From: Nicola Spencer on behalf of Planning
Sent: 18 May 2018 16:02
To: Planning.Responses; Planning Scanning
Subject: FW: Objection A/64/18/T Caffyns Audi
Attachments: Supporting Information A_64_18_T.pdf

From: Michael Fick [REDACTED]
Sent: 18 May 2018 14:19
To: Planning
Subject: Objection A/64/18/T Caffyns Audi

Failure to Comply with the TPO and the Root Protection Area (RPA)

Drawing title
Site Plan

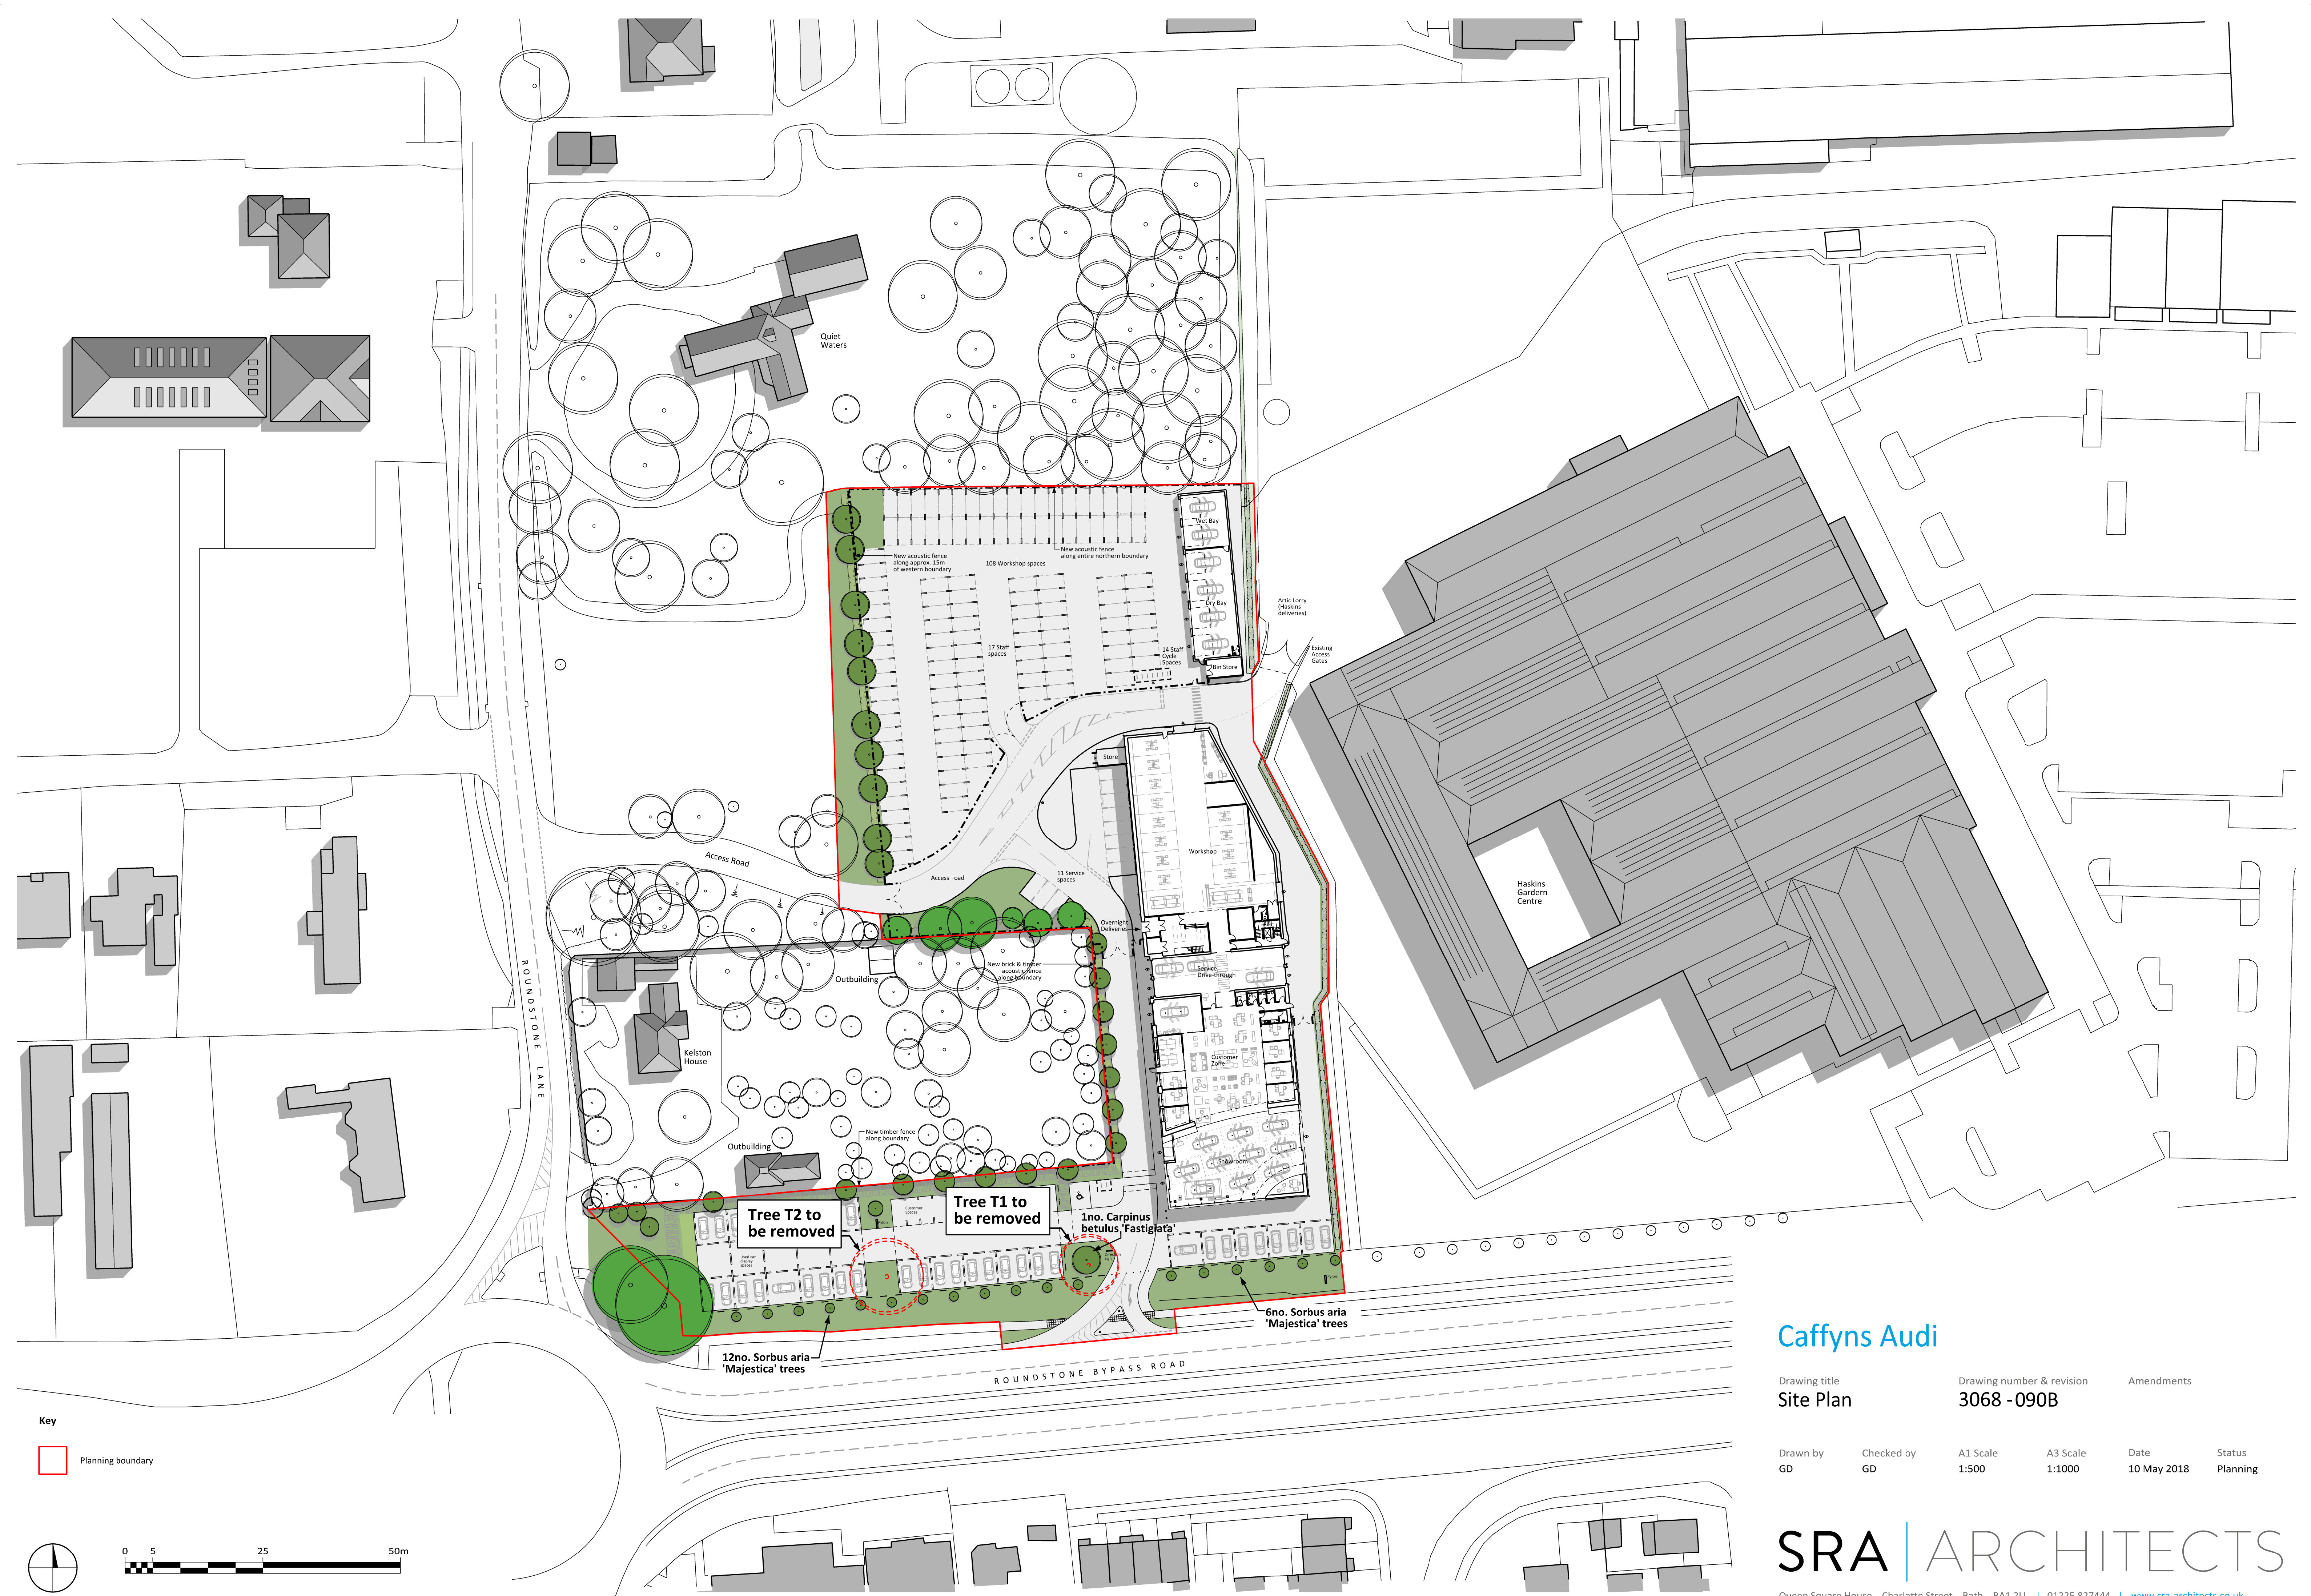
The plans clearly show the proposed car park spaces encroaching into the right hand side of the **western Beech tree's** RPA.

A 4.5m "Used Car" Pylon sign is shown at point "T". It appears to sit uncomfortably on top of a tree. It is also obvious that the **western Beech tree** will hide the sign from the A259 and that its crown will need "ongoing management" so as not to grow over it.

Plan shows the car park encroaching into the western Beech Tree's RPA.
